V1_Drainage Report - Final_Comments.pdf Markup Summary

> PROPOSED GRADING PROFILES

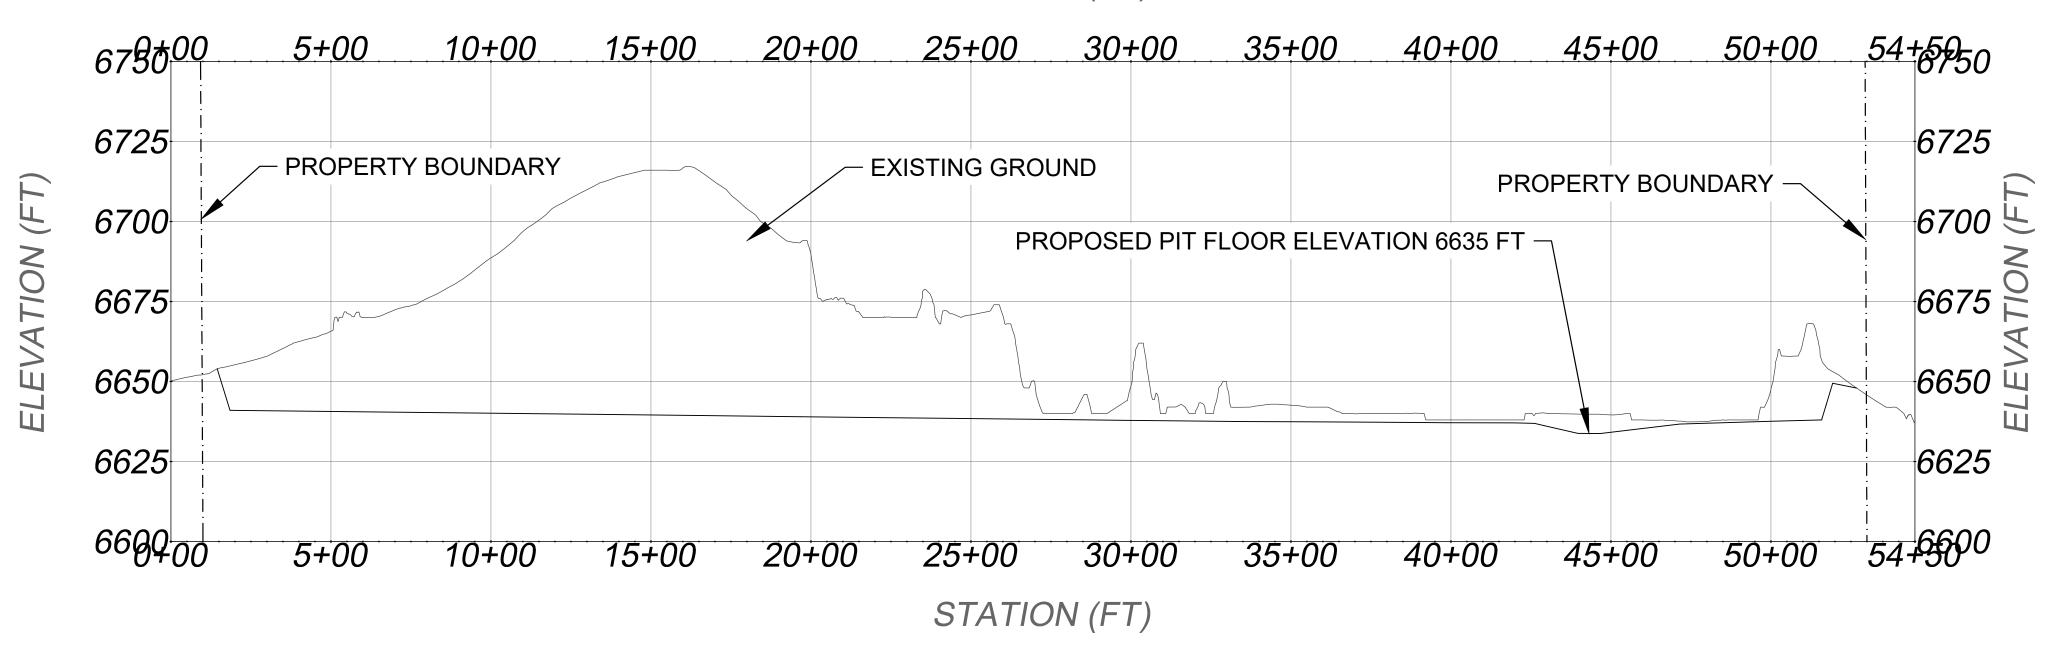
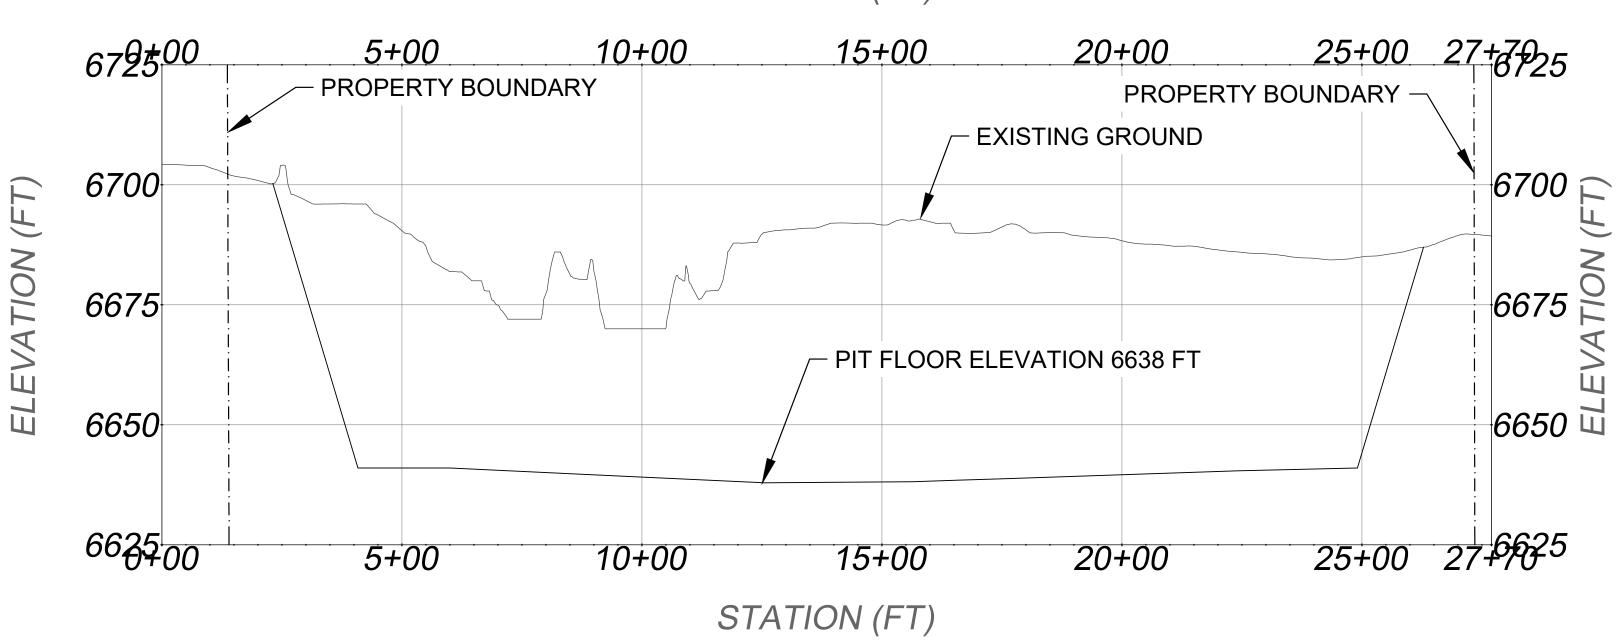
The mining operation plan indicates a depth of 40 ft. revise so that they are consistent with each other
